Administrative Plot Plan

Project Name: 16140 Old Denver Date: _____

Review Agency Comment Sheet

Date:	12/1/16	Review Agency:	PSD Project Management/Planning
File Number:	PPR-16-037	Reviewer:	Nina Ruiz
		Project Manager:	Nina Ruiz (719) 520-6313
Send response comments to: DSDcomments@elpasoco.com			
Project Name:	All About Outdoor Storage		
Request:	A request by Kelly McKoon for approval of a site development plan to allow for outside storage within the I-2 zoning district.		
Commissioner Dist:	1		
Tax ID# (s):	71260-04-002

Phase Two

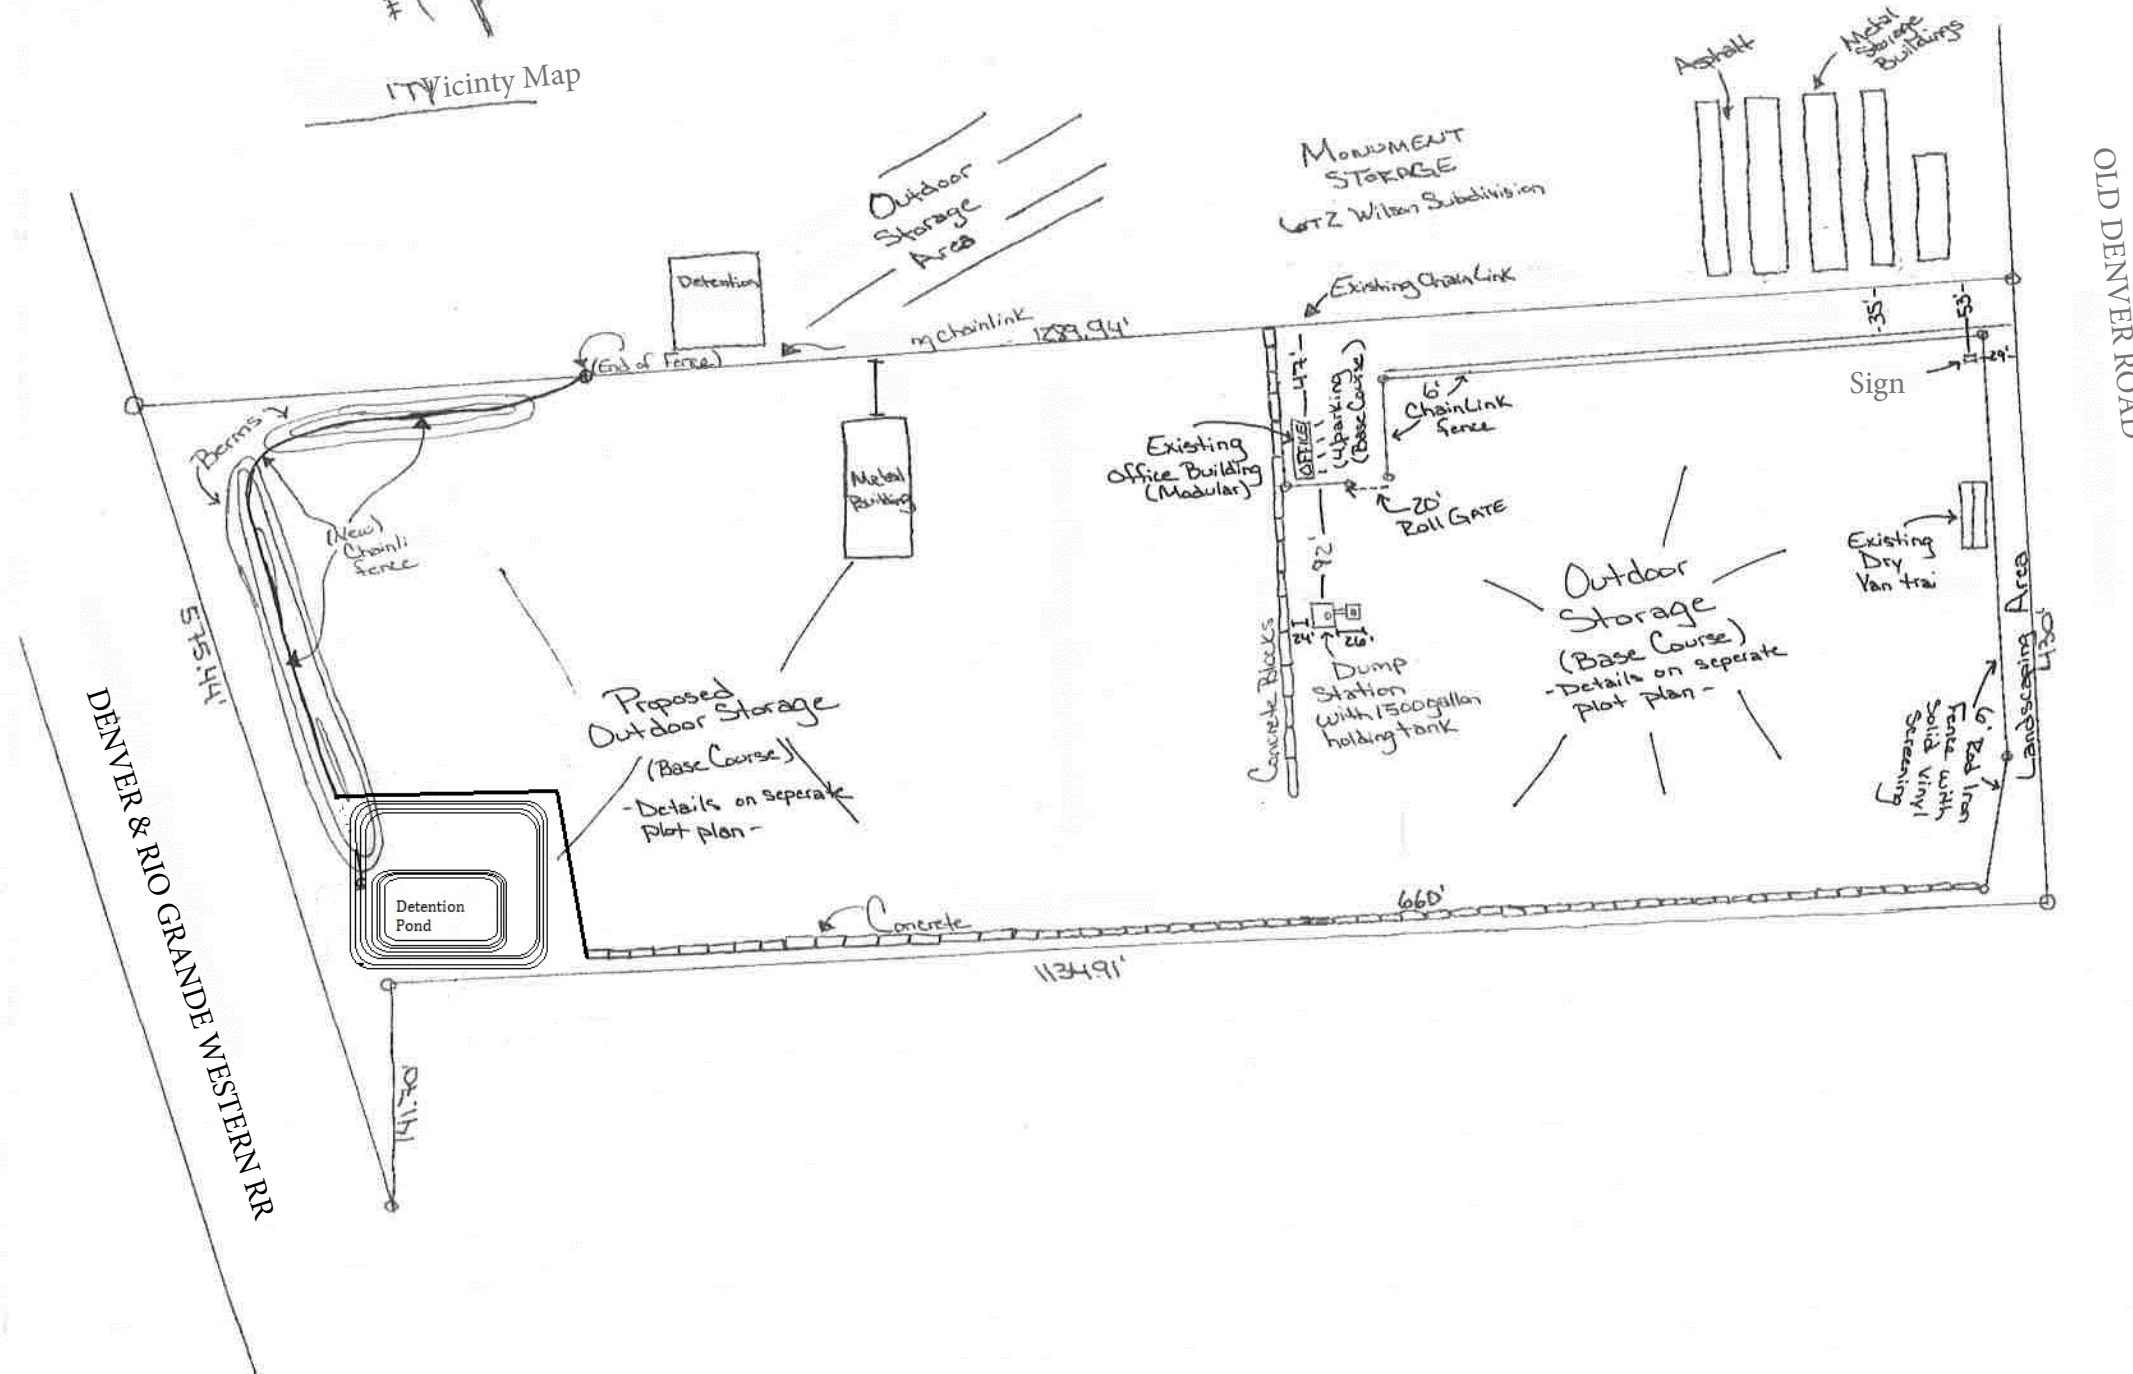
1. Please review the outside storage section of the Land Development Code and revise the plans to meet these requirements. Outside storage must be 100% screened. The proposed fence is not solid.

2. Please add dimensions indicating the setback for the sign as well as the size of the sign (height, square footage).

In order to meet the 100% screening we plan on 1) on the east side of the premises located next to Old Denver Road we will line the rod-iron fence with solid vinyl fence screening (see picture **A** on the next page). 2) On the south and west end of the 6 acres, we propose utilizing concrete blocks as a wall. The blocks are approximately 2' high x 2' wide x 6-8' long. Stacking these blocks will provide a 6 foot high wall that is 100% opaque (see picture **B** on the next page). 3) On the north side of the property we are abut to Monument Storage and request that the screening fence be waived based on 5.2.38 section B (7) "when outside storage areas abut each other and are not visible from public areas, administrative relief may be sought from the requirement for a solid fence between outdoor storage areas." 4) I question the property and business just to the north of us, Monument Storage. They do not have 100% opaque screening in between their storage lot and the business just north of them, Colorado Sports Center. It is my understanding that any outside storage visible from public areas must be opaque?

The sign is located 5 feet west of the rod-iron fence next to Old Denver Road and 10 feet south of the rod-iron fence at the driveway inside the fence. The outside dimensions of the sign are 8 feet wide and 6 feet 3 inches tall. The sign itself is 7 feet wide by 4 feet tall. All other signage from the previous business will be removed.

ALL ABOUT OUTDOOR STORAGE
16140 Old Denver Road
Monument, CO 80132

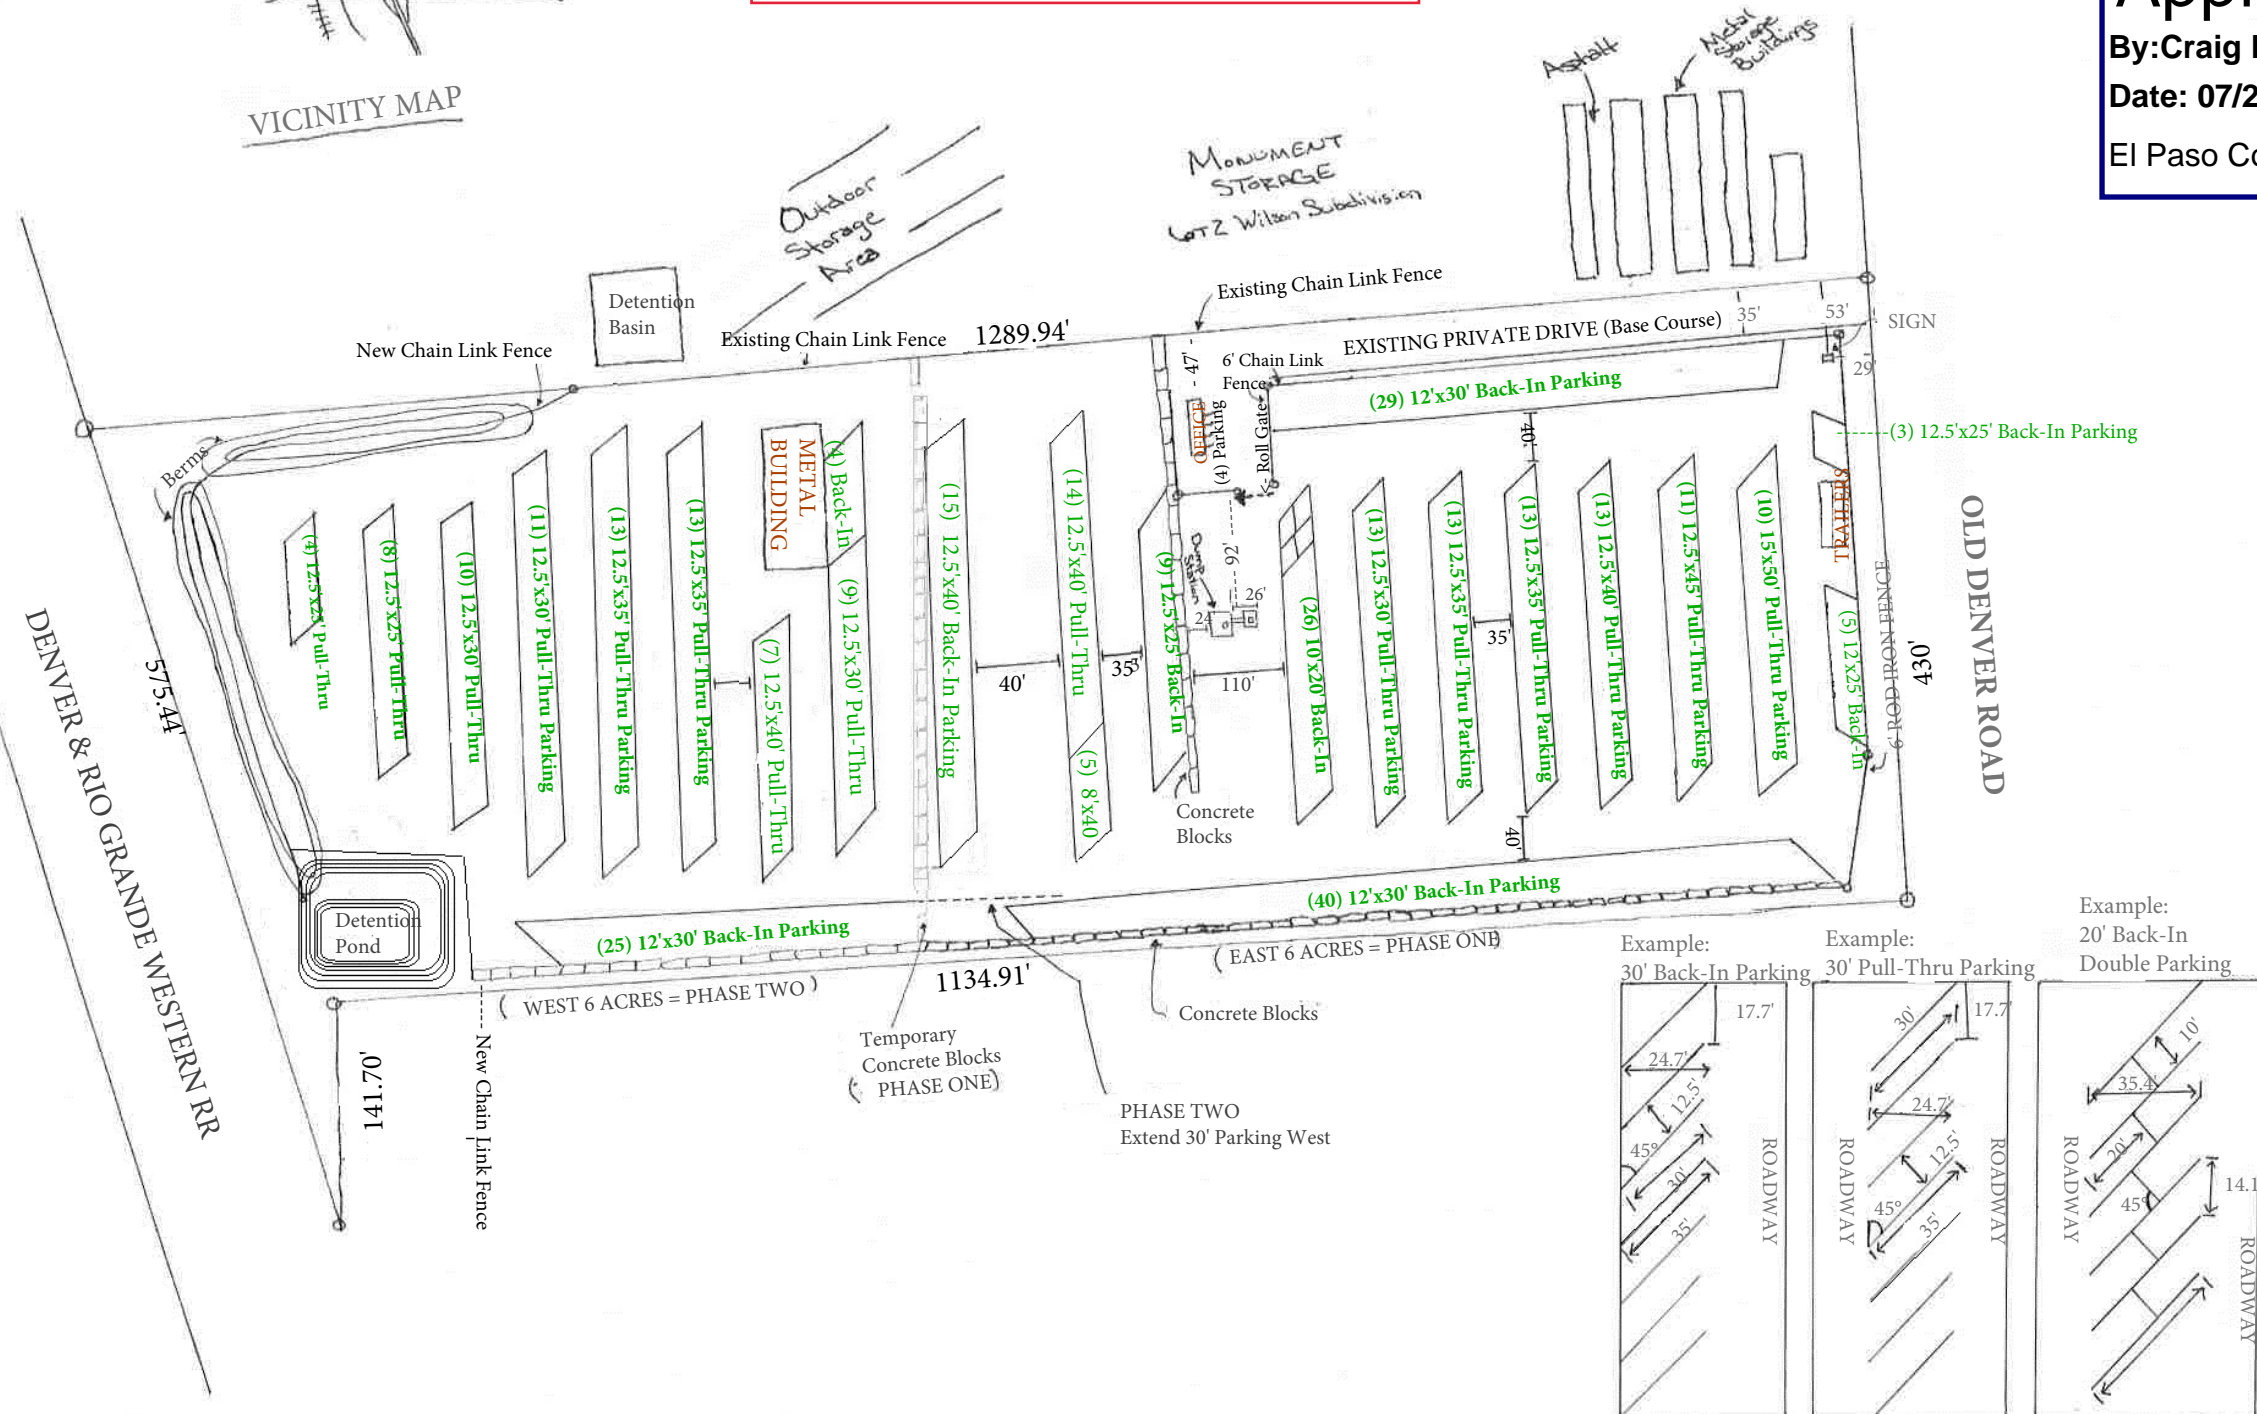
2) The landscaping along Old Denver is inadequate as it is composed of deciduous plants and located on a slope that will not screen the site. We agree to line the fence with a vinyl fence screen that will be 100% opaque. Instead of the landscape plan, we can just rip rap or grass seed the area in between the fence and Old Denver Road, whichever is preferred.
